Our ref: HA/2021/123702/01-L01
Your ref: LU/252/21/PL
Date: 01 December 2021

CHANGE FROM CURRENT 8 BEDROOM LARGE HOUSE IN MULTIPLE OCCUPATION (SUI GENERIS) TO A 9 BEDROOM LARGE HOUSE IN MULTIPLE OCCUPATION (SUI GENERIS). THIS APPLICATION AFFECTS THE CHARACTER & APPEARANCE OF THE LITTLEHAMPTON SEA FRONT CONSERVATION AREA

6 SELBORNE PLACE SELBORNE ROAD LITTLEHAMPTON BN17 5NH

Environment Agency Position

dwg # 054.PL.06a
dwg title Proposed Plans

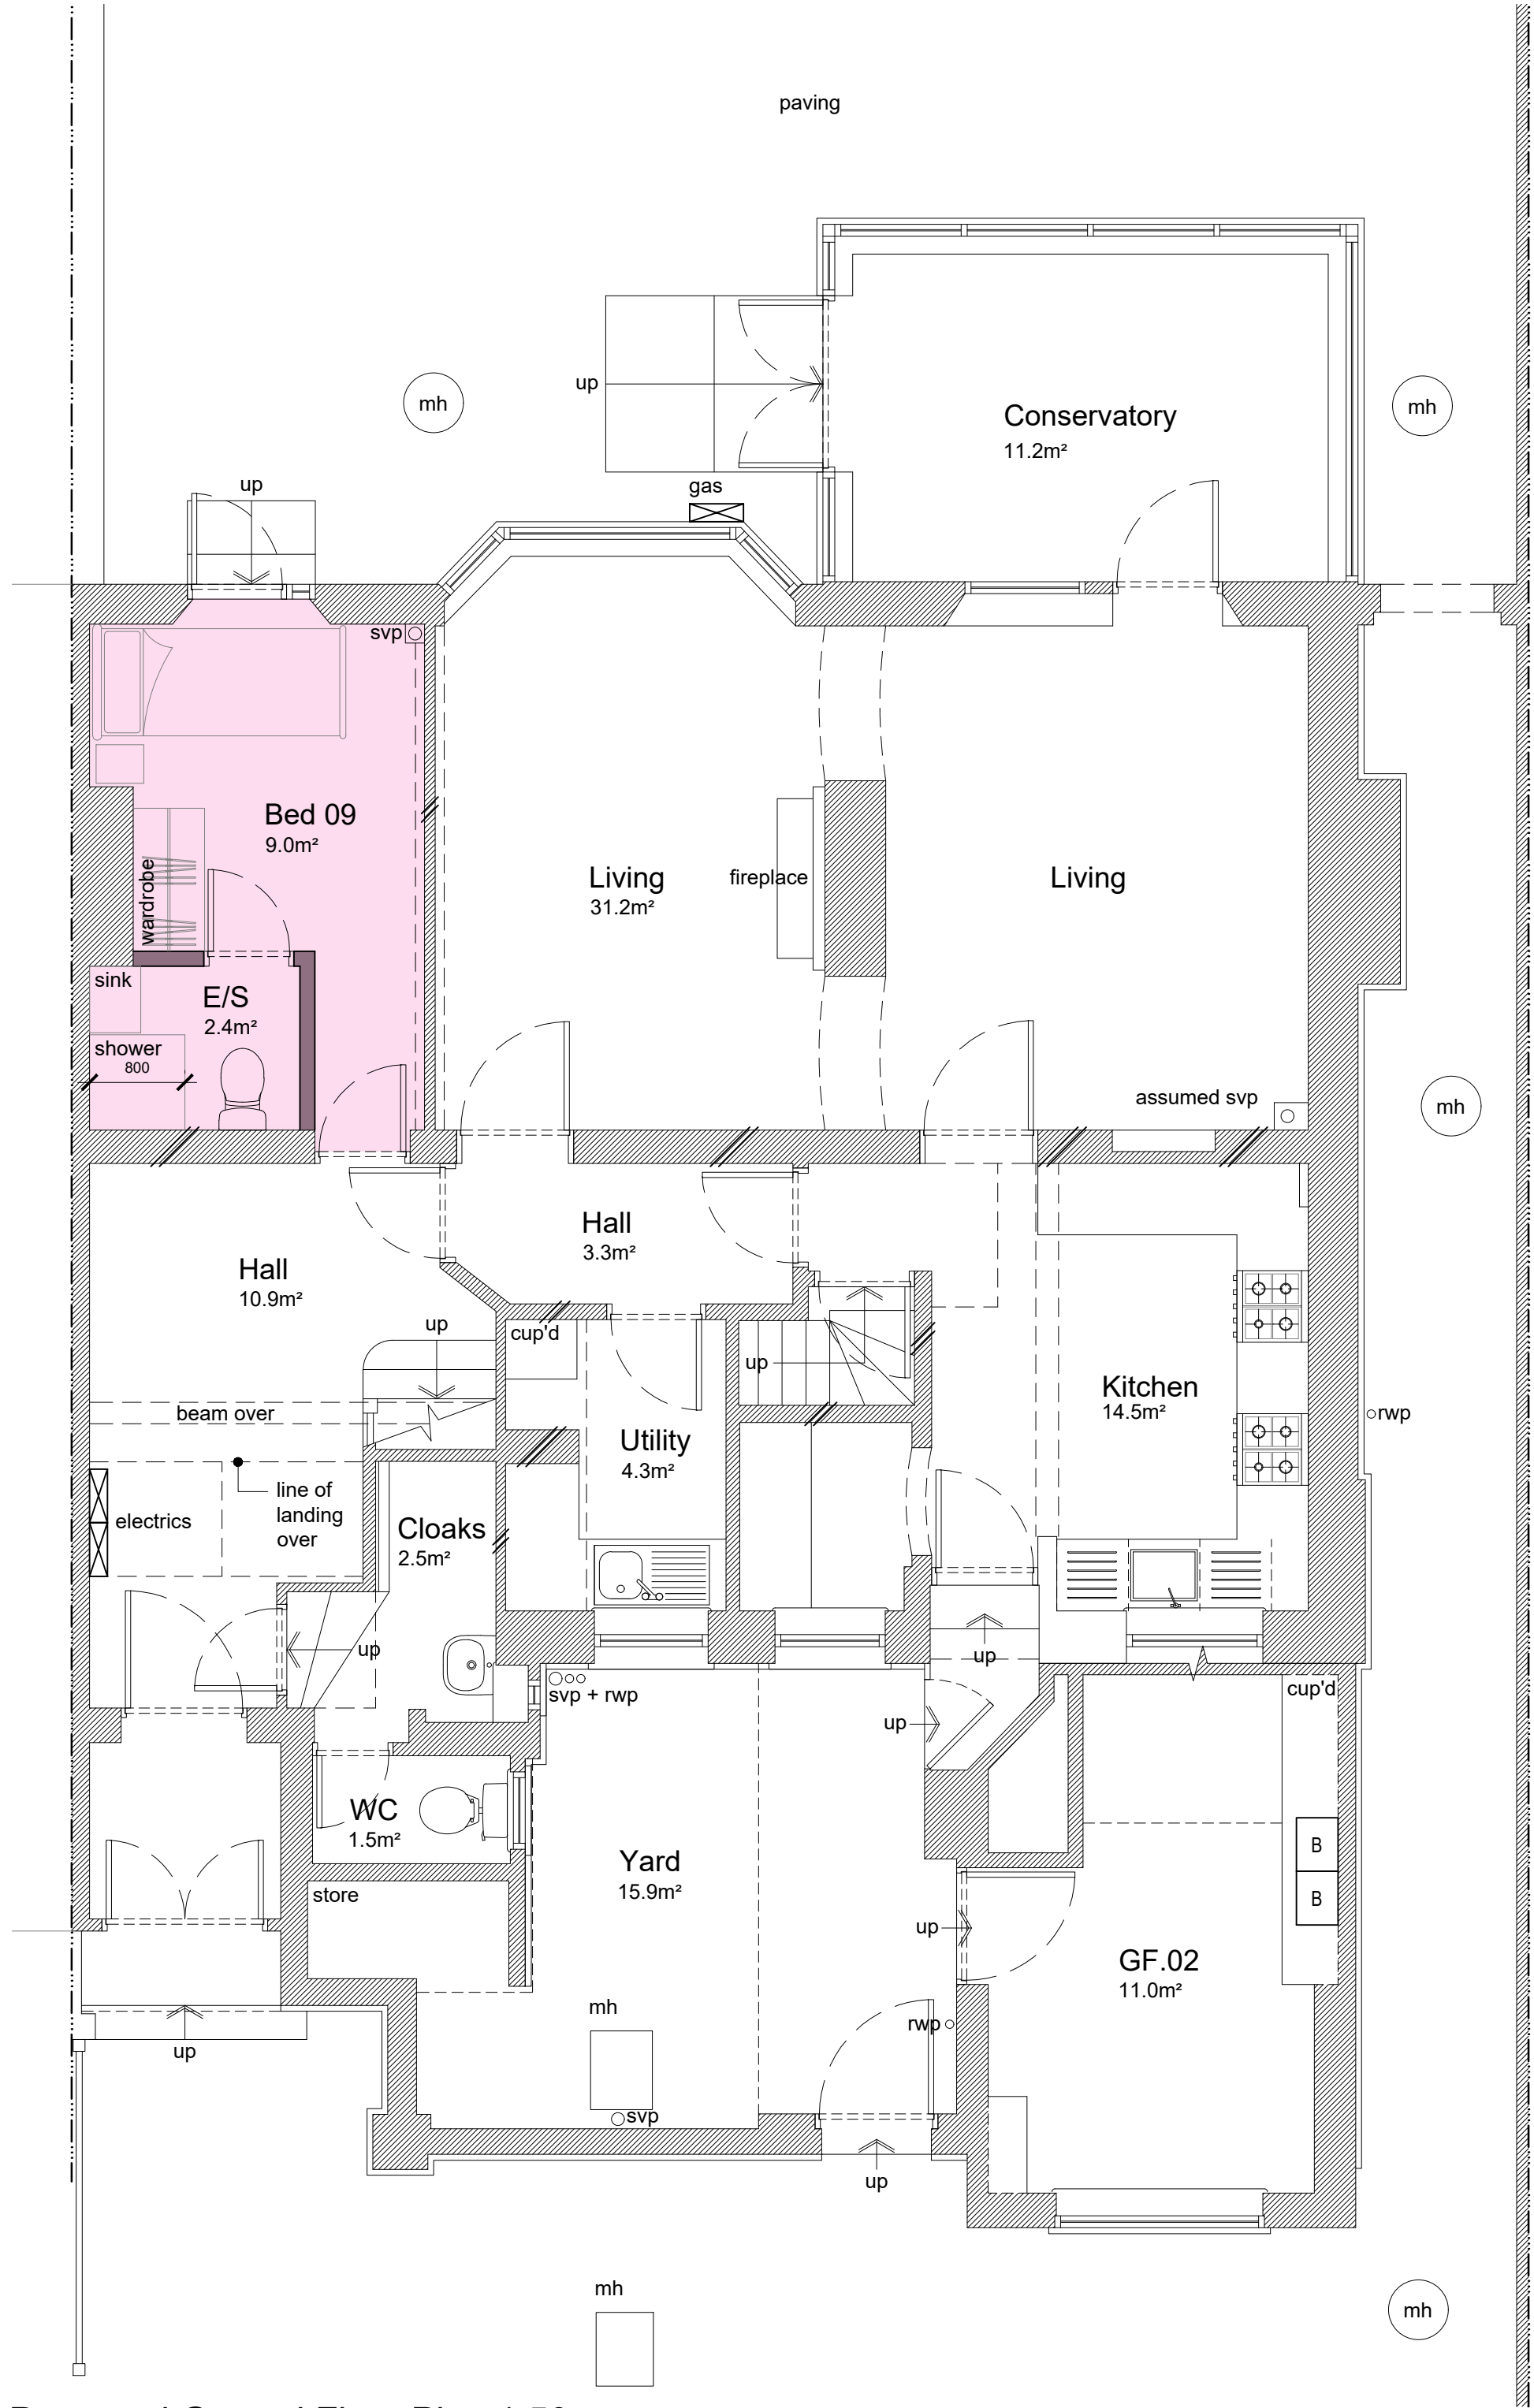
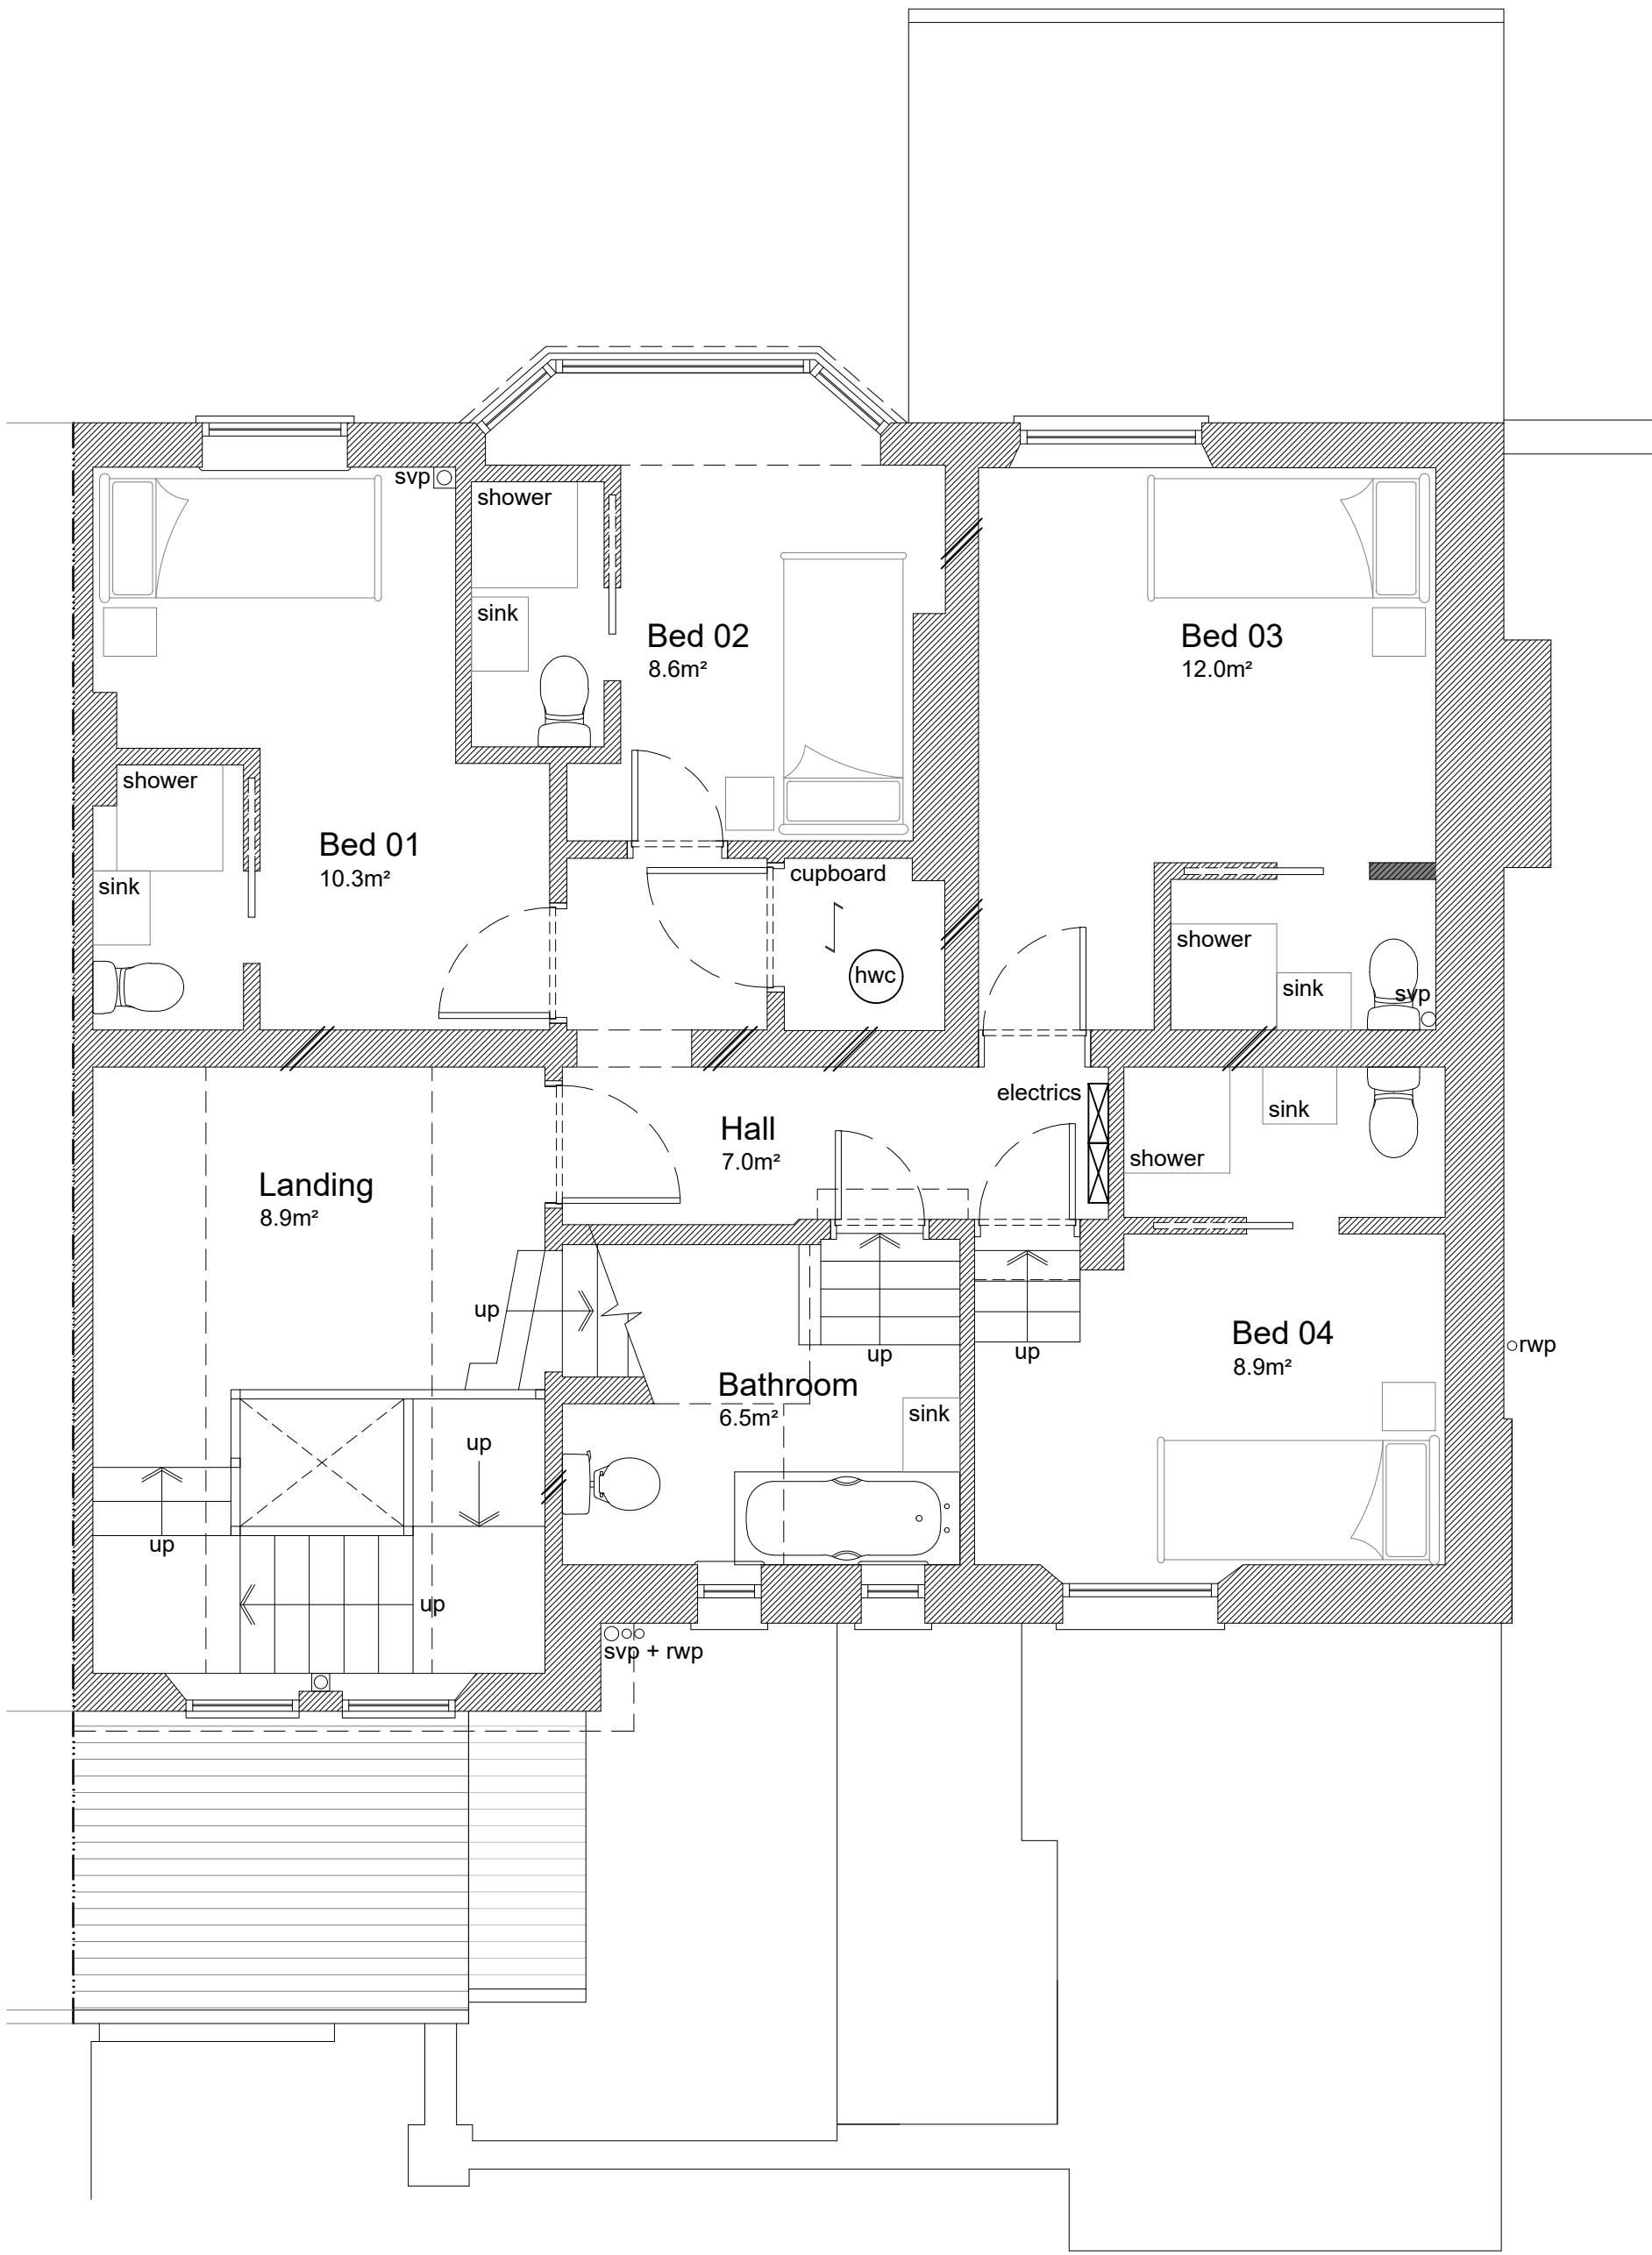
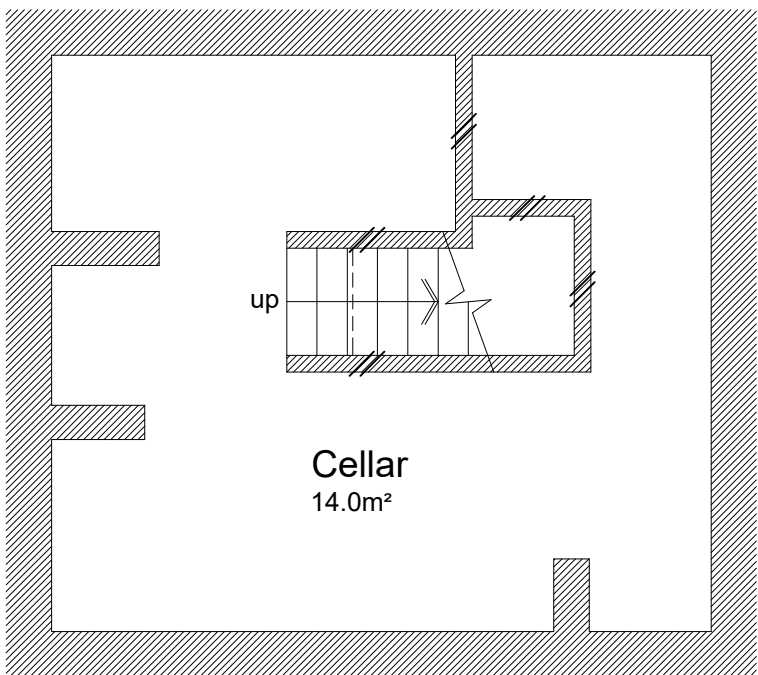
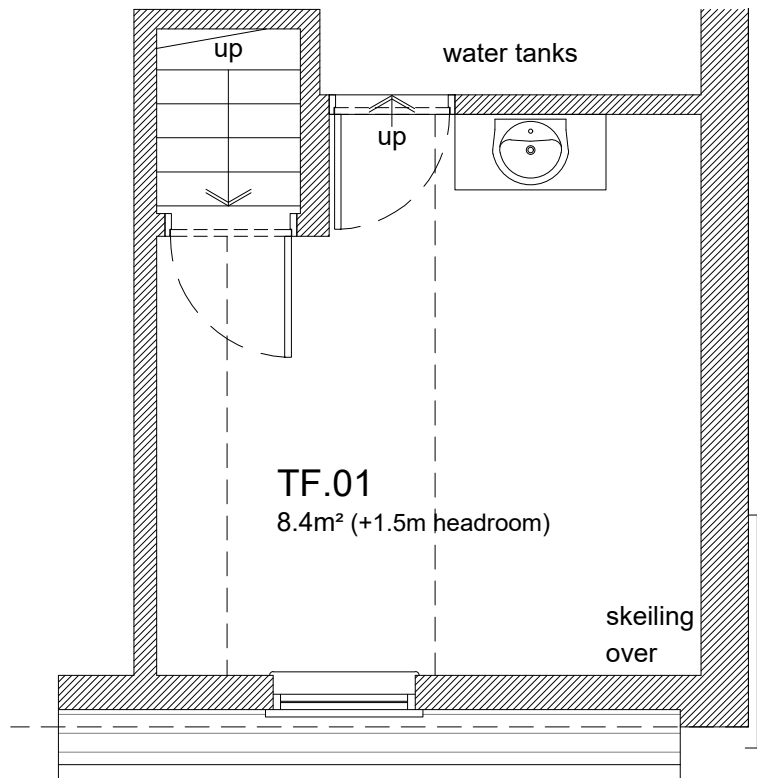
The submitted FRA does not comply with the requirements for site-specific flood risk assessments, as set out in paragraphs 30 to 32 of the Flood Risk and Coastal Change section of the planning practice guidance. The FRA does not therefore adequately assess the flood risks posed by the development. In particular, the FRA fails to:

- Provide a sufficient assessment of the impacts of climate change (2125) and subsequent comparison between site specific finished ground floor levels and modelled flood levels

To overcome our objection, the applicant should submit a revised FRA and amended plans which addresses the points highlighted above.

We would recommend that sleeping accommodation is placed at least 300mm above the modelled flood levels (0.5% plus climate change allowances 2125), reducing the risk to occupants for the lifetime of the development.
